PLANNING AMENDMENT

Application No. H17/0021/01/A2

Description: Conversion of methodist church
to dwelling

**Conversion of Methodist Church to dwelling at
Station Road, Surfleet, Spalding, Lincs
Reference No: H17/0021/01**

14250 - 14 B

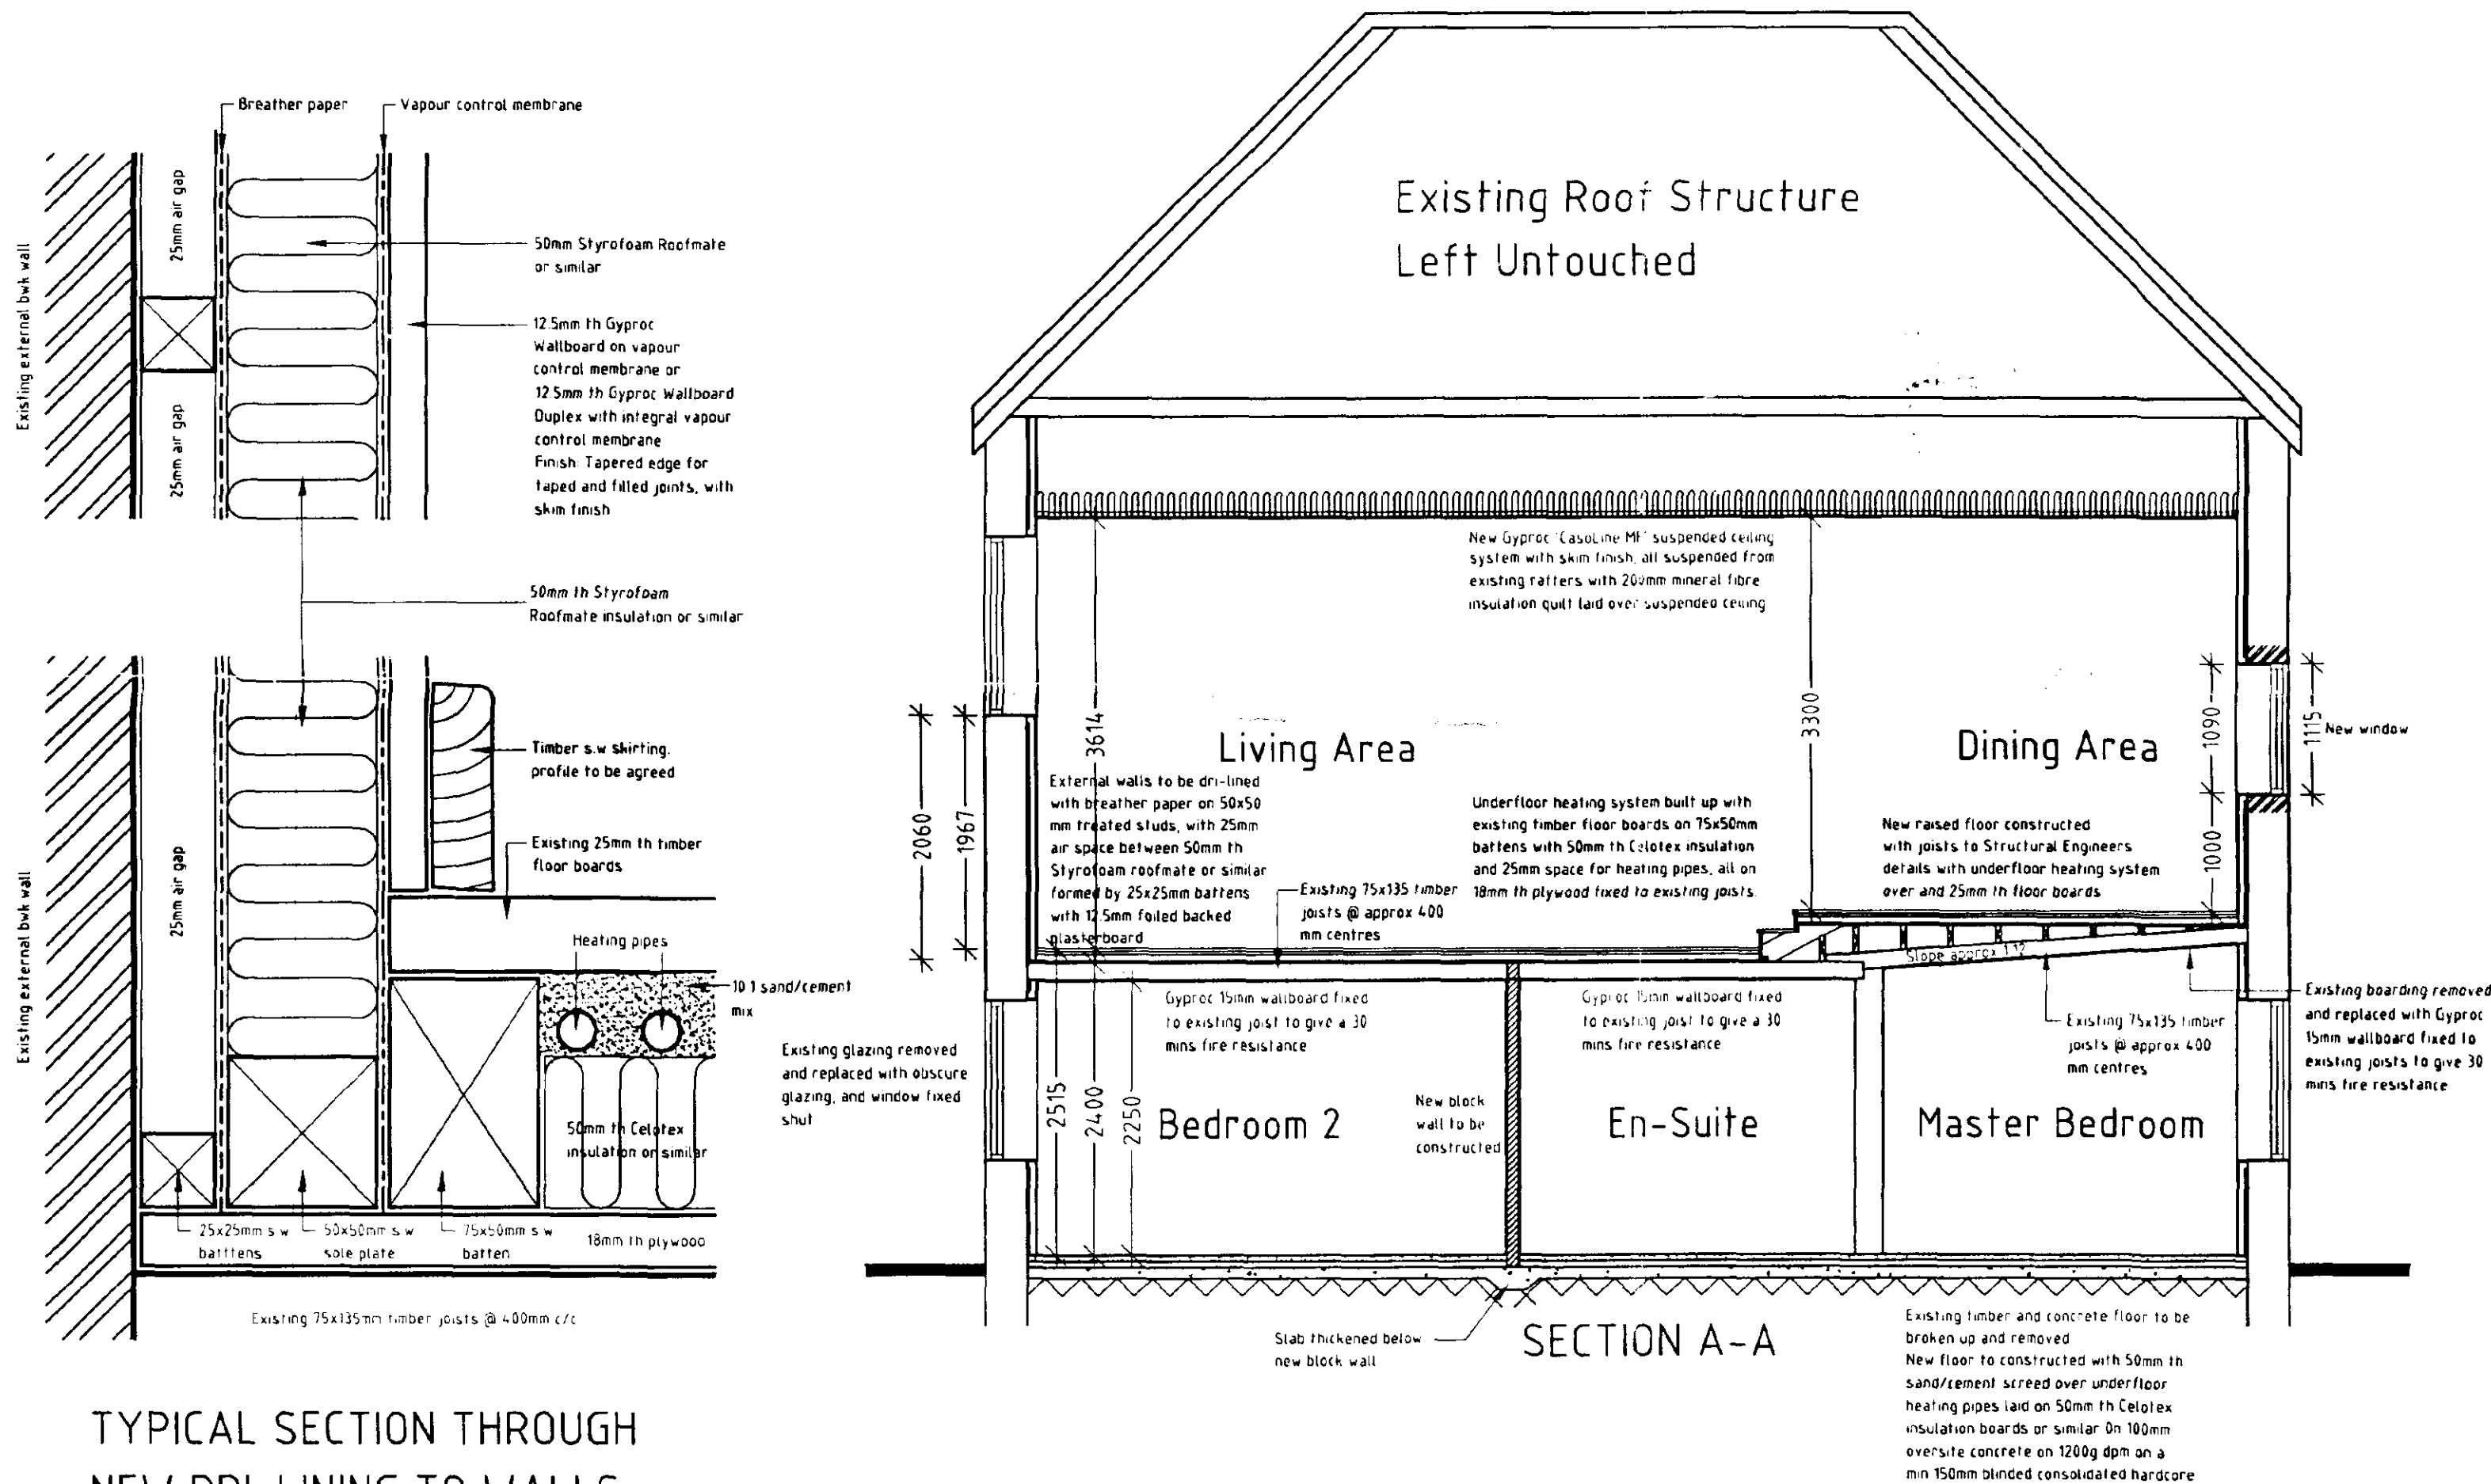
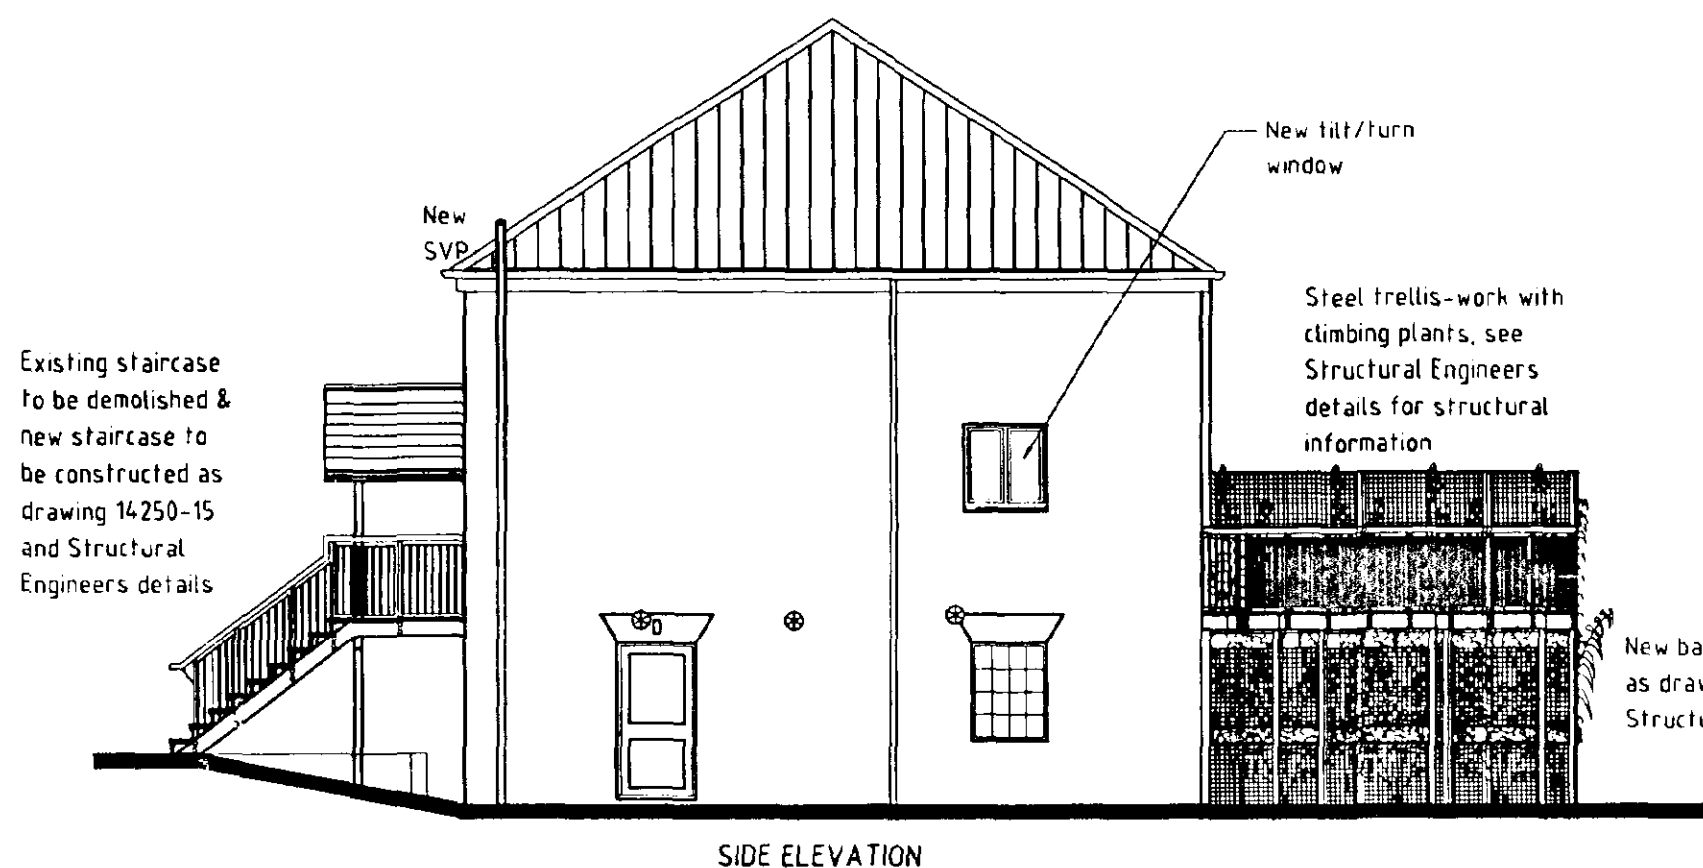
Amendment: Amendments to floor levels only
Dwg no. 14250-14B

Further to construction changes to the above property please find enclosed 4 copies of drawing number 14250-14B (Section 1:50) to replace drawing 138/00-05 (submitted by G R Merchant on 7 March 2001) for your comment and approval.

1. Drawing 138/00-05 shows the existing floor raised by approx 200mm, which goes against condition 3 of the planning approval. New drawing 14250-14B shows the floor finishes being raised by approx 75mm to incorporate a new underfloor heating system, resulting in a cill level of 1967mm to windows overlooking the garden of 53 Station Road. *original drawings 138/00-05*
2. The cill height to new window to dining area (south west elevation) has been reduced to 1000mm. *needs PP.*

The insertion of the new window will require
planning permission owing to Condition 9.

Note: The insertion of the new words will require planning permission as to cat 3.

Amendment ok because doesn't conflict with cat 3
level of existing plan does not change & level of
new planning actually lower than level shown on
approved plan is ok

14250 - 12 A

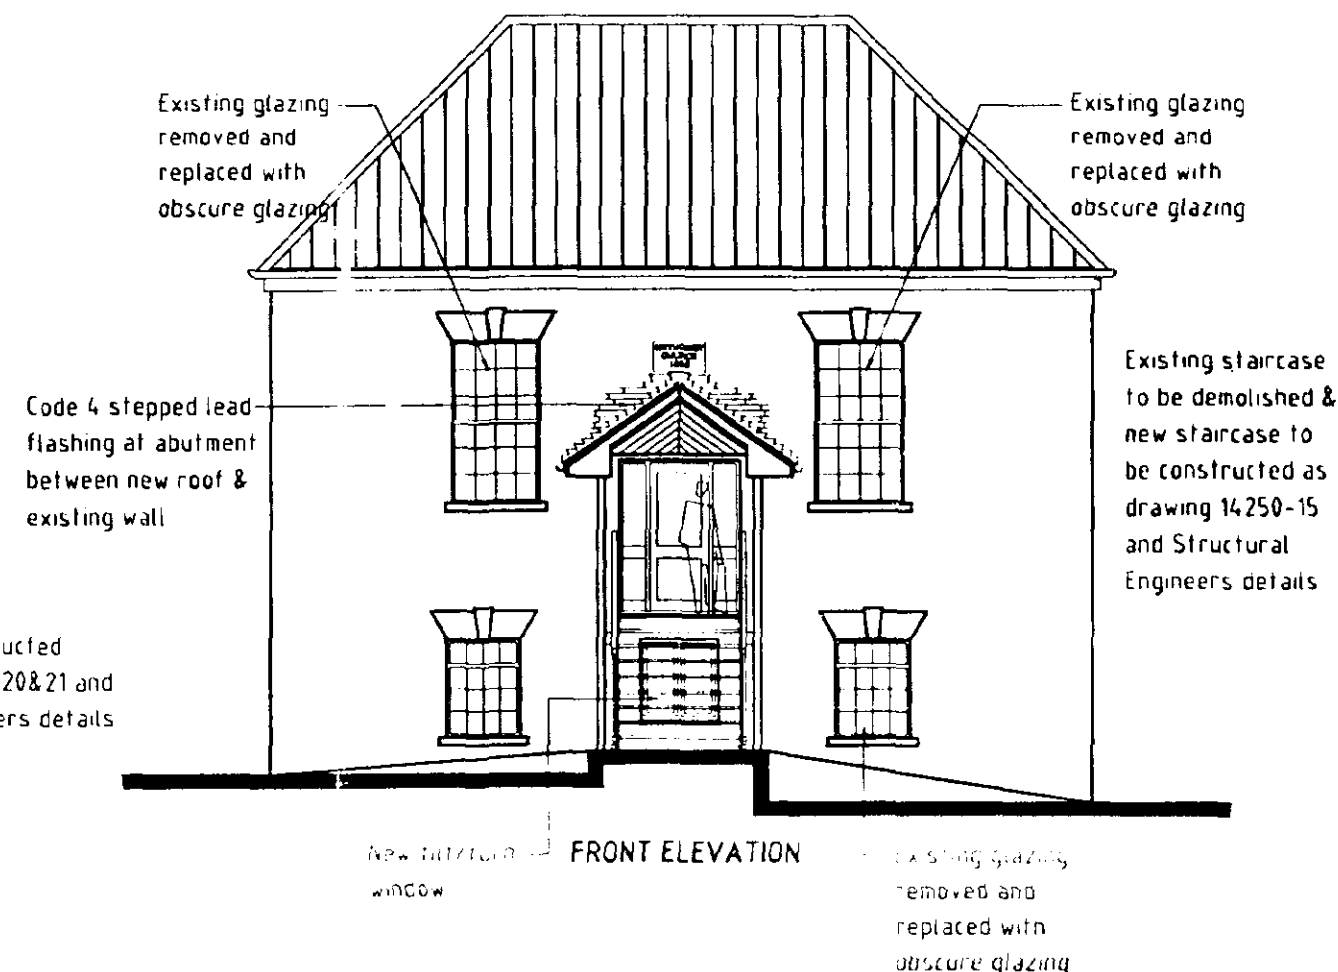
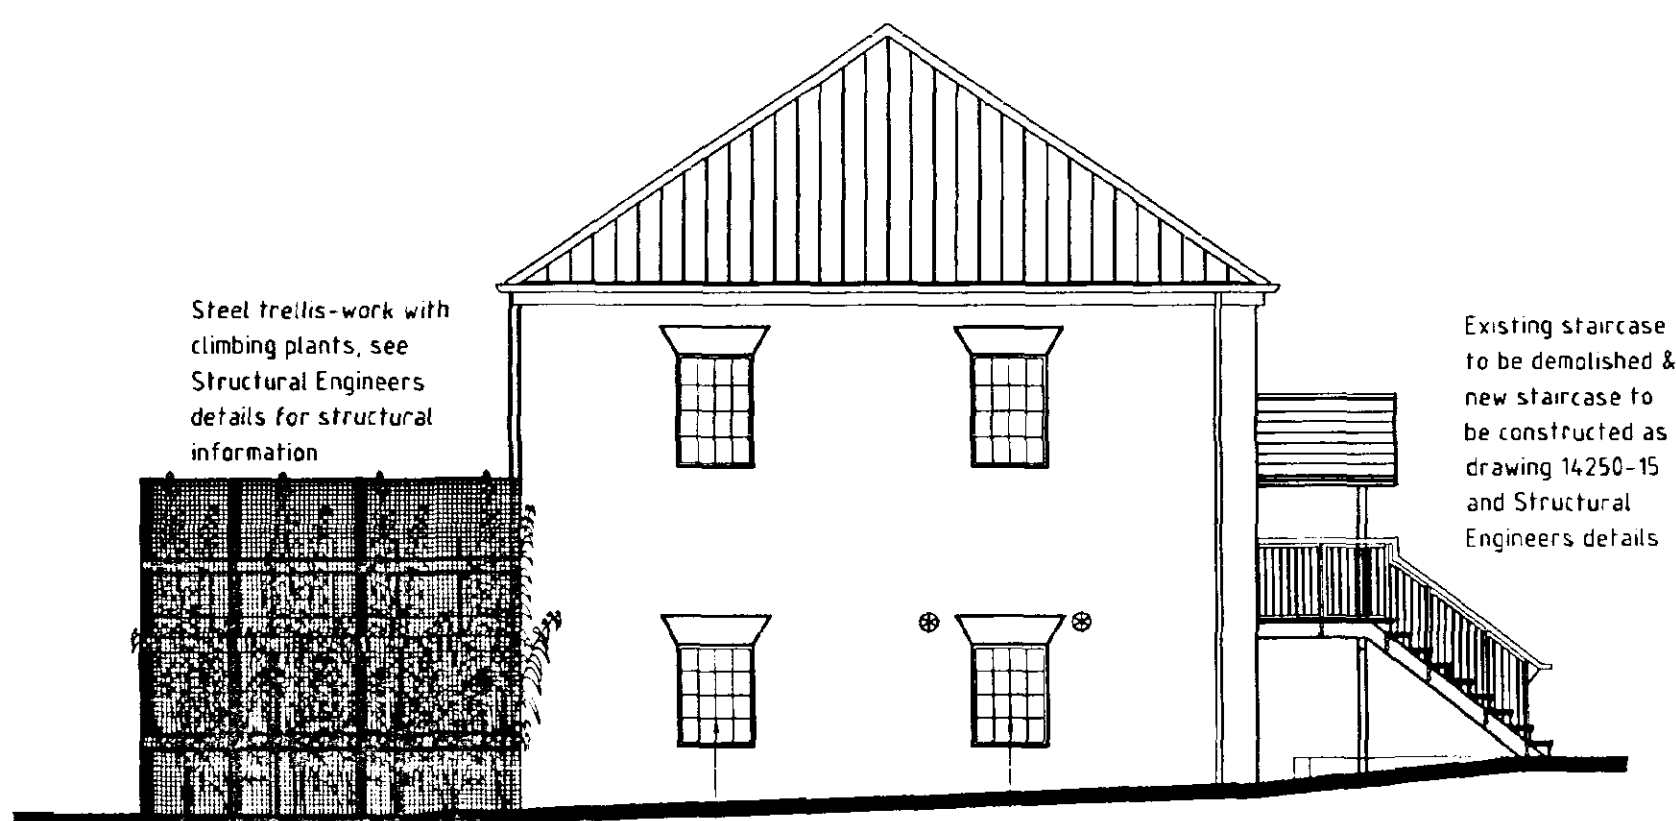
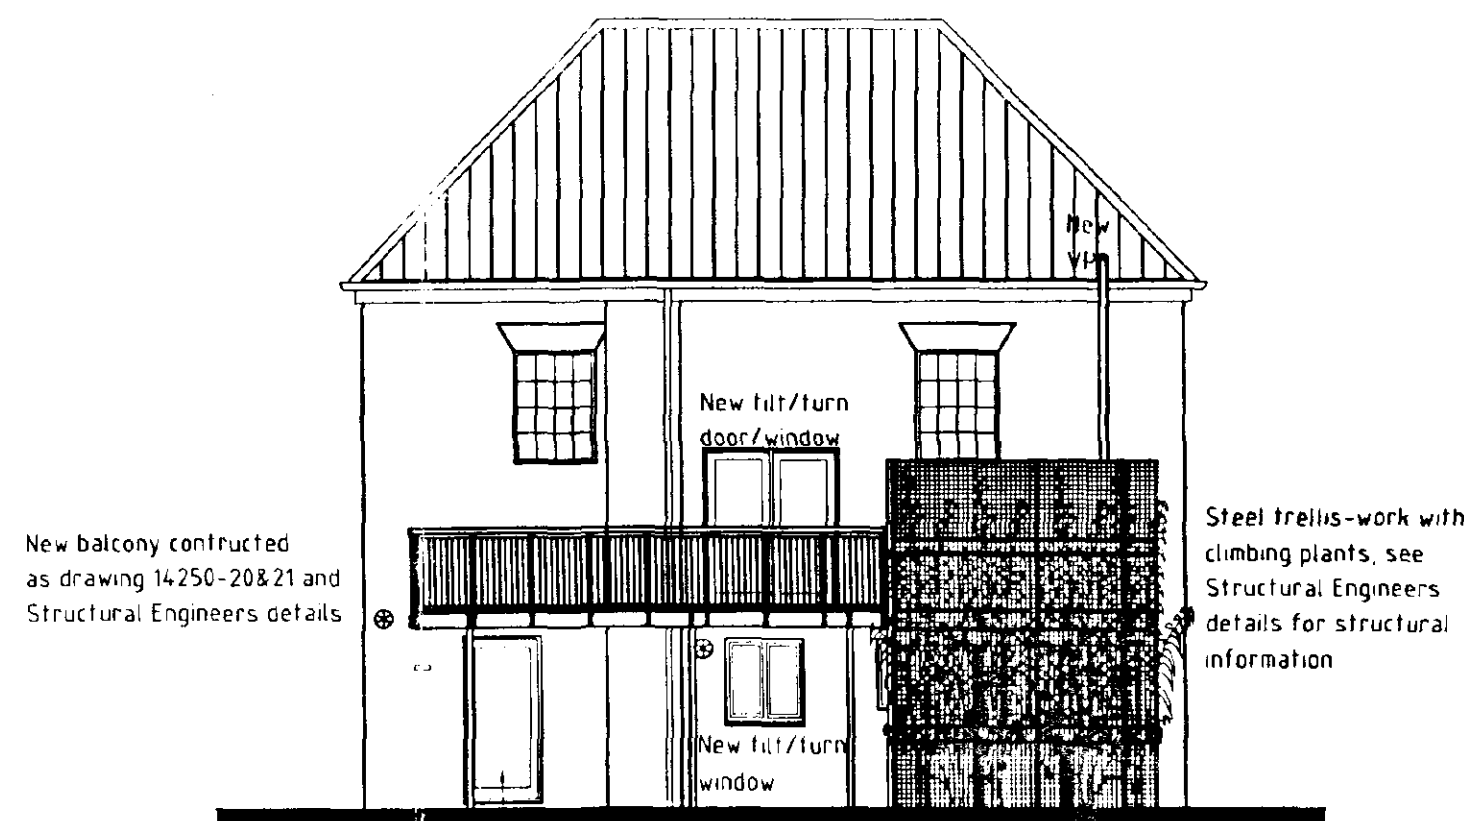
1. *OK* At ground floor level on the front elevation the window directly beneath the new external staircase has been amended from glass block screen to window.
2. *OK* At ground floor level the existing external door to the bathroom is now to be retained not replaced by a window as originally proposed.
3. *OK* At ground floor level, the proposals for new rear doors to the master bedroom have been changed from a pair of doors to a single door.
4. *OK* Minor amendments (as a result of technical development) have been made to the proposed external entrance staircase.
5. *OK* Minor amendments (as a result of technical development) have been made to the front door design.
6. *OK* The first floor balcony access doors have been changed to open in.
7. *OK* The eill height of the proposed new window to the dining room has been reduced.

For the avoidance of doubt, the two following items are not accepted as part of this amendment:

- 1) The balcony design, which will be submitted as a Condition Compliance.
- 2) The change to the cill height of the new window to the dining area. Such a change is contrary to Condition 9 and therefore Planning Permission is required. The window as shown on the scheme prepared by G.R. Merchant on drawing number 138/00/02, can be installed in accordance with the Planning Permission.
